Our Ref: BR/128/20/DOC

Approval of details reserved by condition imposed under BR/219/18/PL for condition 4-surface water drainage; 5-colour schedule of materials & finishes, 6-dustbin enclosures details; 7-electrical vehicle charging points, 8-incorporation of decentralised, renewable, low carbon energy supply system, 9-vehicular access details & 11-cycle parking space details.

9 Westloats Lane Bognor Regis PO21 5JZ

Sheet
 1A

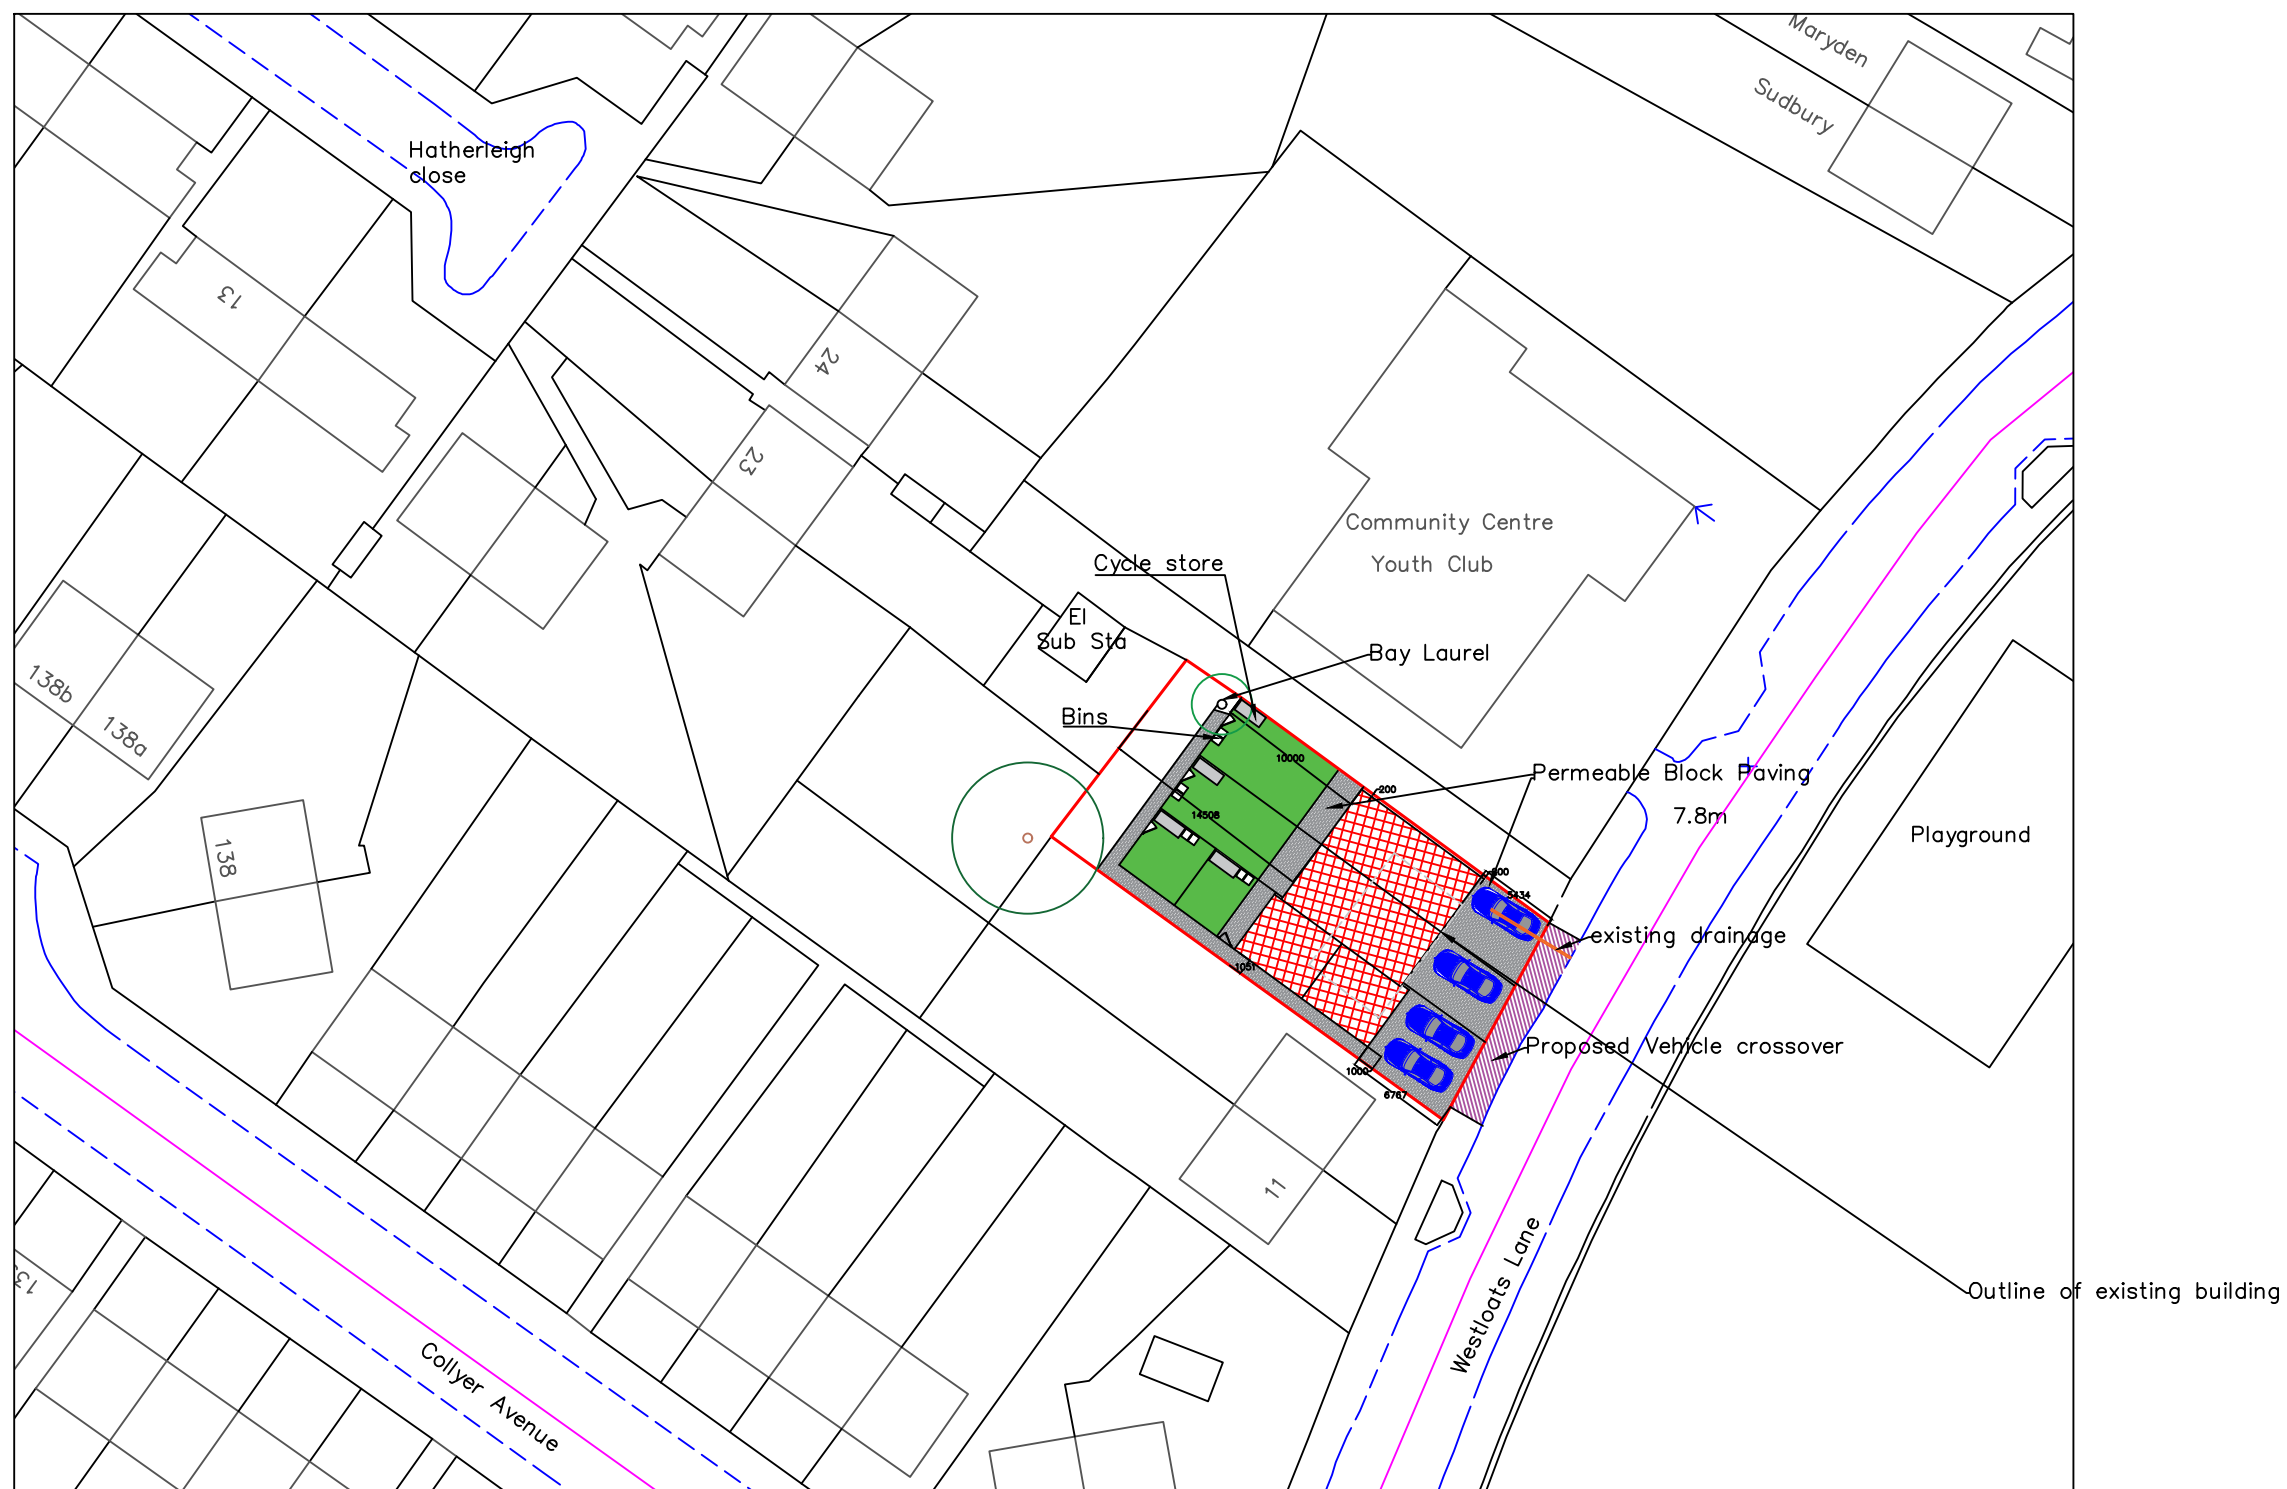
This condition is discharged in so far as submission of details relates and refers to the provision of dustbin enclosure measuring 1.2m x 0.8m x 1.34m indicated on the Proposed Site Plan Sheet 1A, including photo of proposed type.
